# Cuan Na Loinge Road Protection Scheme

Stage 1 Road Safety Audit

This report describes the findings of a Stage 1 Road Safety Audit associated with the Cuan Na Loinge Road Protection Scheme.

PROPOSED ROAD ALIGNMENT CROSS SECTIONS

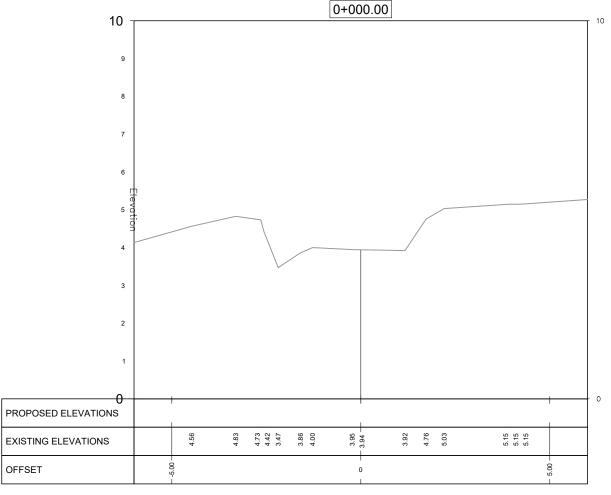
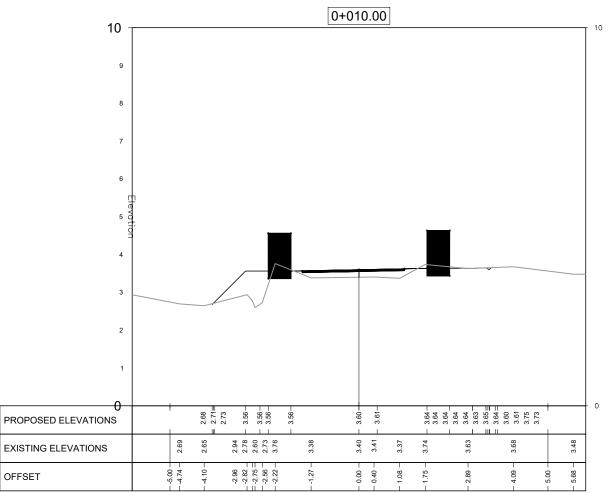
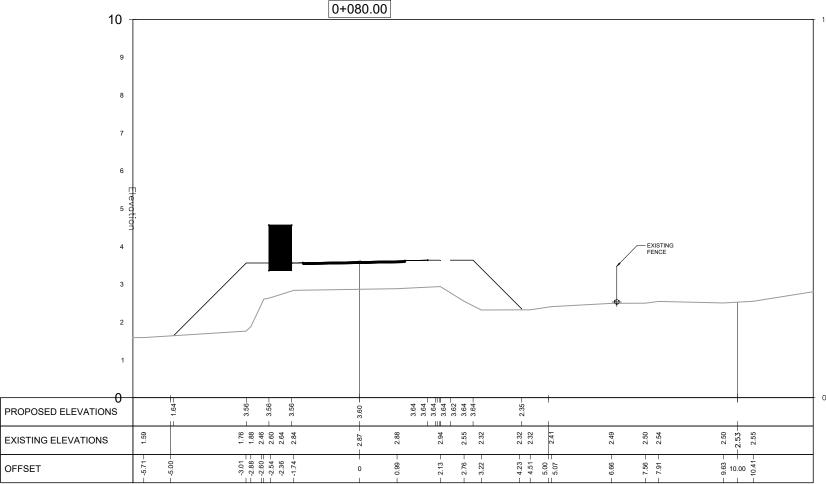
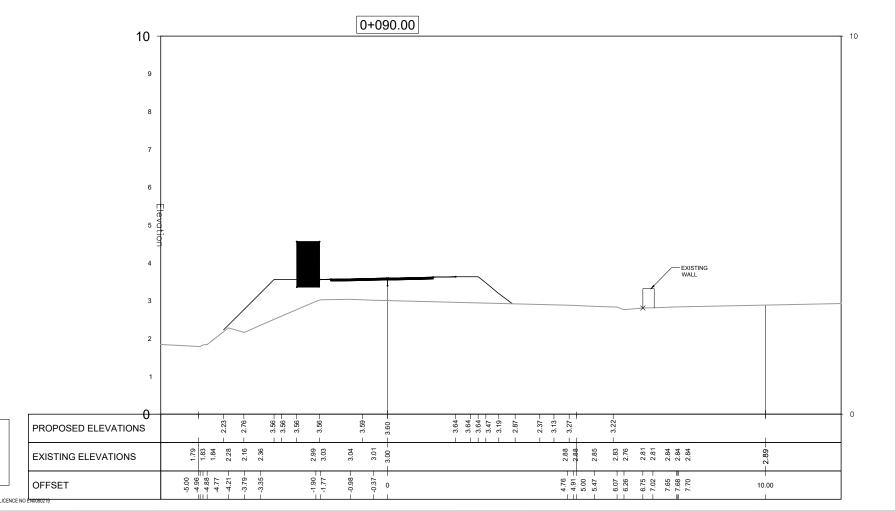
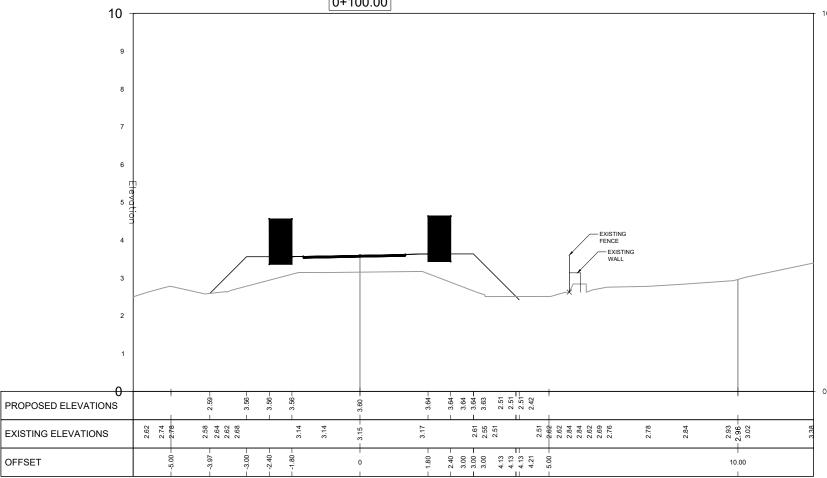
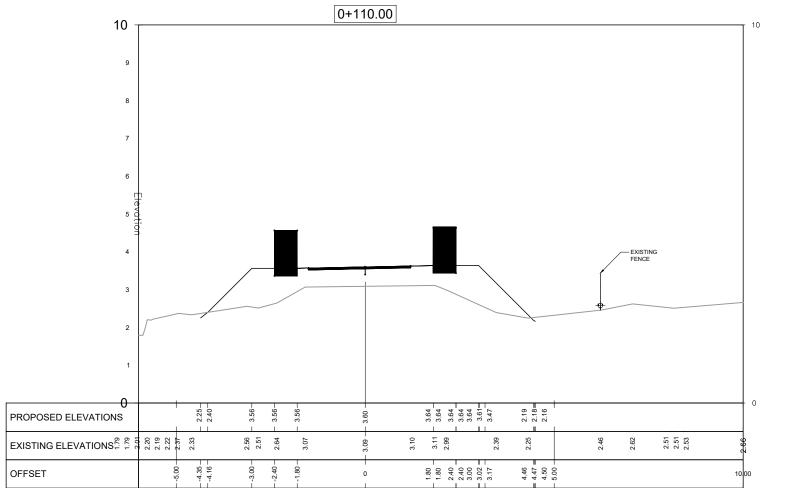
The varying widths of road pavement, flood protection walls, and verge space pose risks to pedestrians who might unexpectedly step in front of approaching vehicles.

An appropriate horizontal alignment should be established for the road to offer a continuous and consistent pedestrian refuge area, allowing walkers to step aside safely when vehicles approach.

Flood protection walls may reduce visibility between opposing drivers on roads with varying pavement widths. The walls are likely to limit safe passing opportunities, causing risky reversing manoeuvres, conflicts, and driver frustration.

A suitable horizontal alignment should be developed for the road which provides for locations where two opposing vehicles can pass each other, connected by a consistent and predictable traffic lane.

Problem Reference (Section 2)	Designer Response Section			Audit Team Response Section
	Problem Accepted ( yes / no )	Recommended Measure Accepted ( yes / no )	Alternative Measures or Comments	Alternative Measures Accepted ( yes / no )
2.1	Yes	Yes	<p>Object of the scheme is to improve the safety of all road uses</p> <p>This provided by providing a consistent verge on the southern verge.</p> <p>Actions required: Currently no pedestrian access provision</p> <p>Reduce carriageway width to 2.7.m</p> <p>Target northern verge width =0.3</p> <p>Southern verge . 0.3+ 0.3 = 0.6m</p> <p>No road marking required</p> <p>Update cross-sections + plan to emphasis this</p>	Comment noted & accepted.
2.2	Yes	Yes		-
2.3	Yes	Yes		-

PROPOSED SIDE ROAD B
ALIGNMENT CROSS SECTIONS

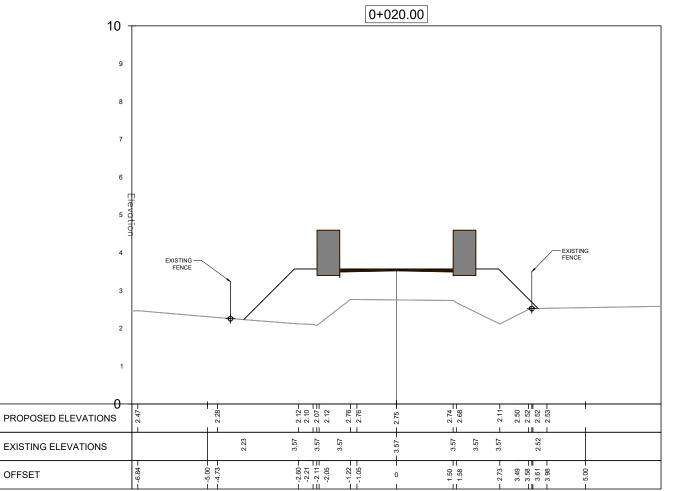
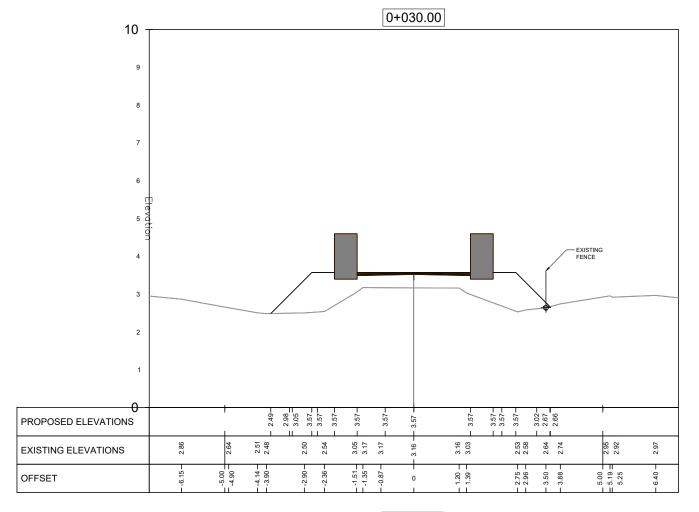
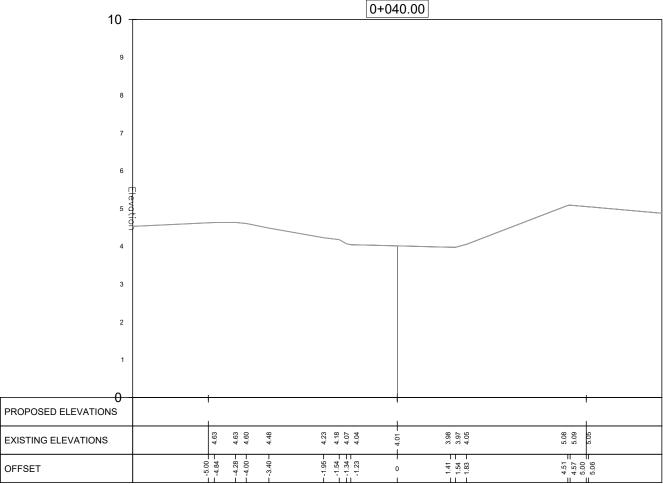
The flood protection walls could serve to reduce sight lines for drivers approaching side road A and side road B junctions, increasing the risk of a side impact type collisions.

Check sight lines at junctions in both vertical and horizontal planes and adjust the position of the flood protection walls as needed.
